CITY OF ALBUQUERQUE

**RE: Gonzales Residence
9801 Cody Ct NW
Requested for Permanent C. O. – Not Accepted
Engineers Stamp Date 11/4/16 (B12D013)
Certification dated: 4-3-17**

ENGINEER'S SEAL	LOT 17, BLOCK 25 PARADISE HILLS 9801 CODY COURT NW	DRAWN BY JDG
	GRADING AND DRAINAGE PLAN	DATE 11-04-2016
	11/4/16	 <i>Rio Grande Engineering</i> 1606 CENTRAL AVENUE SE SUITE 201 ALBUQUERQUE, NM 87106 (505) 872-0999
DAVID SOULE P.E. #14522		JOB #

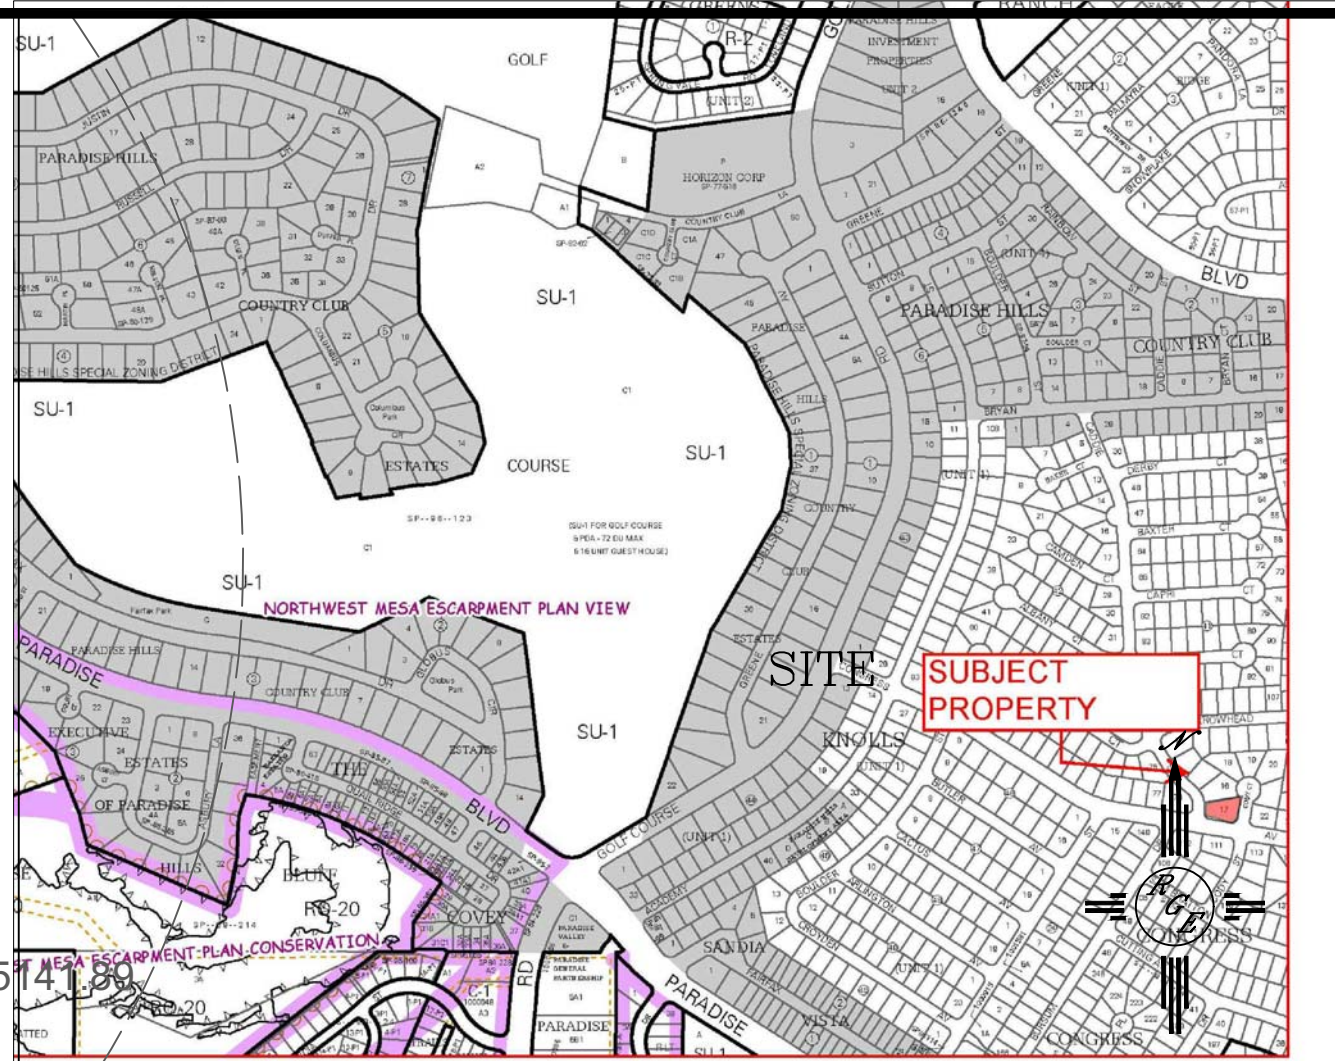
- The pond in the front yard is incomplete.
- A wall that is not on the approved plan was constructed the middle of front yard pond.
- There is no Turn Block @ 36" in the front yard retaining wall.
- The approved drawing calls out the garage wall as a 2' curb/retaining wall. Needs clarification.
- Construction debris covers the front yard and impedes the flows on the west side of the front yard that are coming from the backyard.
